Appeal NO: ABP 310x66-21

Re: Irish Water Observations for ABP-310466-21 – Substitute Consent Application, Windmillhill, Rathcoole, Co. Dublin.

Please accept this submission in respect of the above-referenced further development of a Quarry in Windmillhill, Rathcoole, Co. Dublin.

**Figure 6.18: Local Water Mains (Irish Water), Foul Water Systems (Irish Water), Private Water Supply Wells and Private Wastewater Treatment Systems (in 2021, aerial imagery is from 2020).**

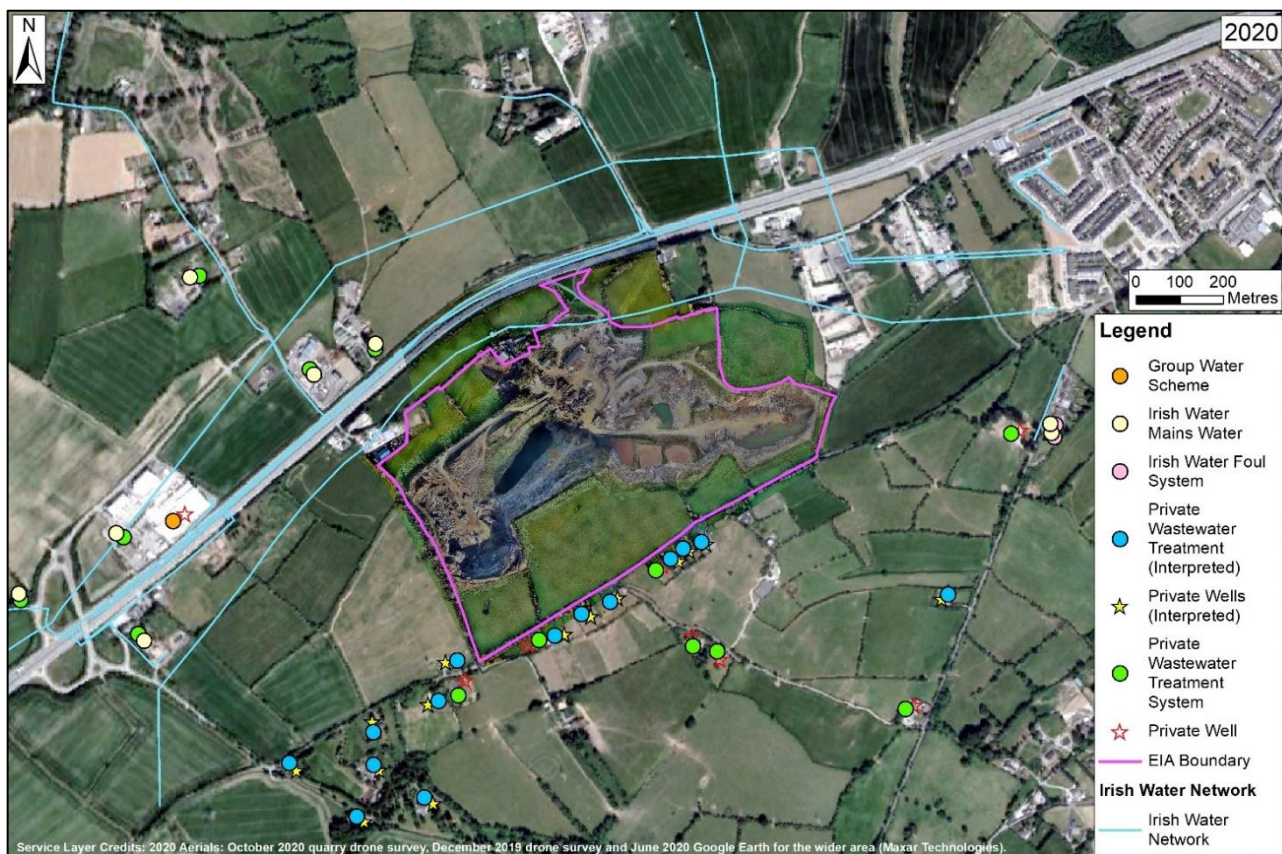
Irish Water notes the proposed development works are located in close proximity to existing IW asset(s) which include strategic **1600mm and 1270mm** concrete trunk mains. The proposed development works include blasting which gives rise to vibrations and other related activities have the potential to significantly impact critical public infrastructure and other Irish Water assets in the area.

1. Prior to any works commencing the applicants/operators shall engage with Irish Water to agree construction/works
2. Prior to any blasting commencing the applicants/operators shall engage with Irish Water to agree construction/works
- 3 The applicant shall ensure no deterioration in the water quality and treatability of any IW drinking water sources, abstraction point(s) and/or watercourses in the area having connectivity with IW drinking water sources, arising from any preconstruction, construction or post construction, blasting. Works and/or operational, post operational activities
- 4 The applicant shall ensure that any and all surface/ground water source(s) within proximity to the proposed site are protected from any possible pollution

- 5 The applicant shall ensure that there will be no negative impact to any of Irish Waters Groundwater Source(s) which may be in proximity to the development during both construction and operational phases of the development to ensure compliance with the Groundwater Directive (80/68/EEC).
- 6 Irish Water does not permit any build over of its assets and separation distances as per Irish Waters Standards Codes and Practices must be achieved. Where any proposals by the applicant to build over or divert existing water or wastewater services subsequently occurs the applicant shall submit details to Irish Water for assessment of feasibility and have written confirmation of feasibility of diversion(s) from Irish Water
